MORAY COUNCIL

PLANNING CONSULTATION RESPONSE

From: Moray Flood Risk Management

Planning Application Ref. No: 21/00030/AMC

Site Plan
Scale 1:200

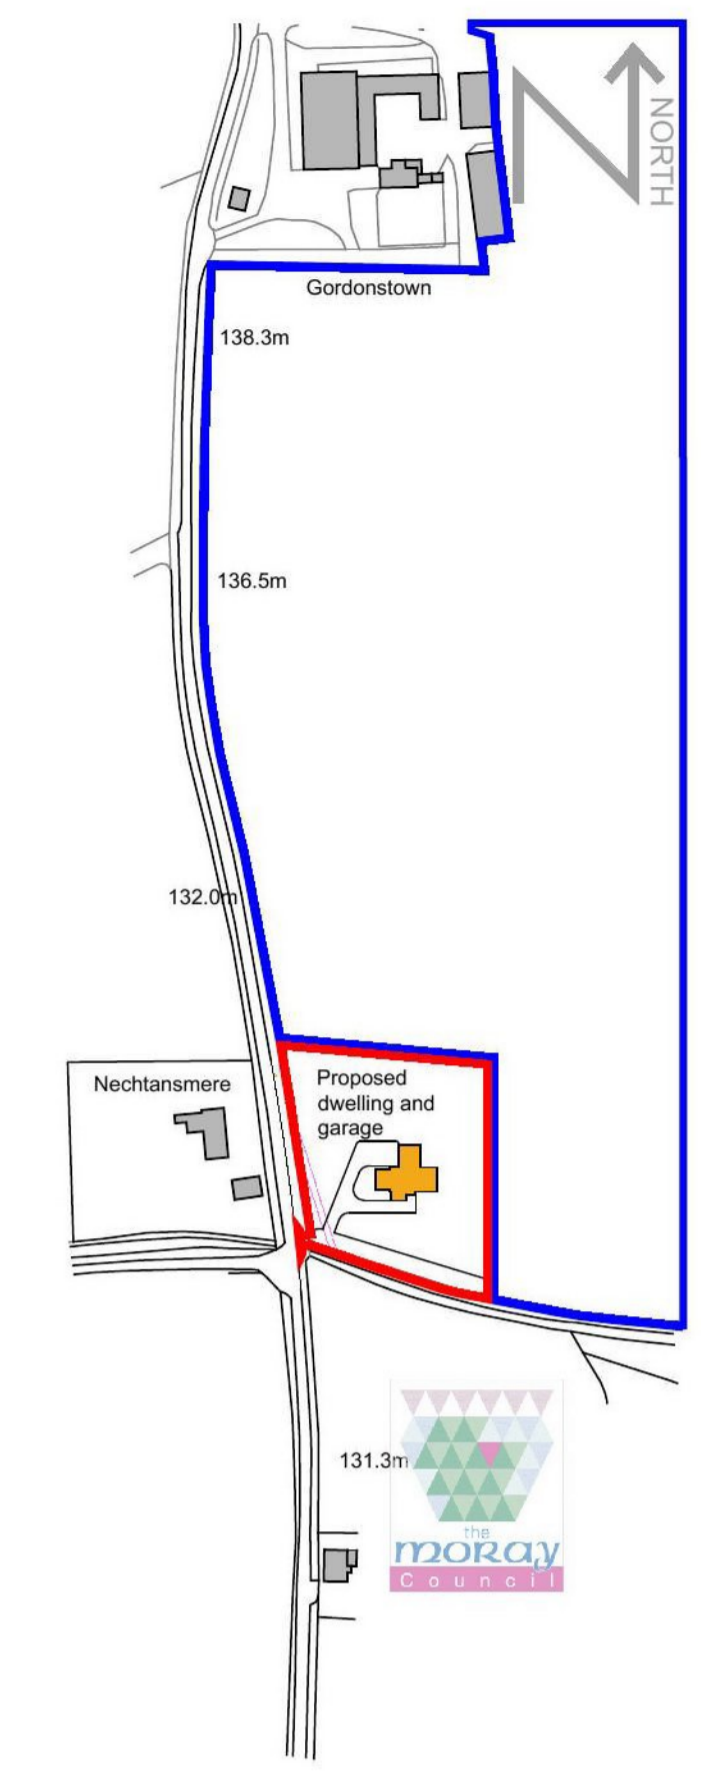
There are several components missing from the drainage design including details for attenuation and discharge into the field drain.

Details for the rain water attenuation system must be provided for the site. This should include calculations to demonstrate that the system is designed to hold the volume of water for a minimum of a 1:30 year return period, including climate change.

Details also need to be provided for how the applicant intends to control the outflow of discharge of surface water into the nearby field drain. The output should be restricted to a maximum flow of the greenfield run off rate.
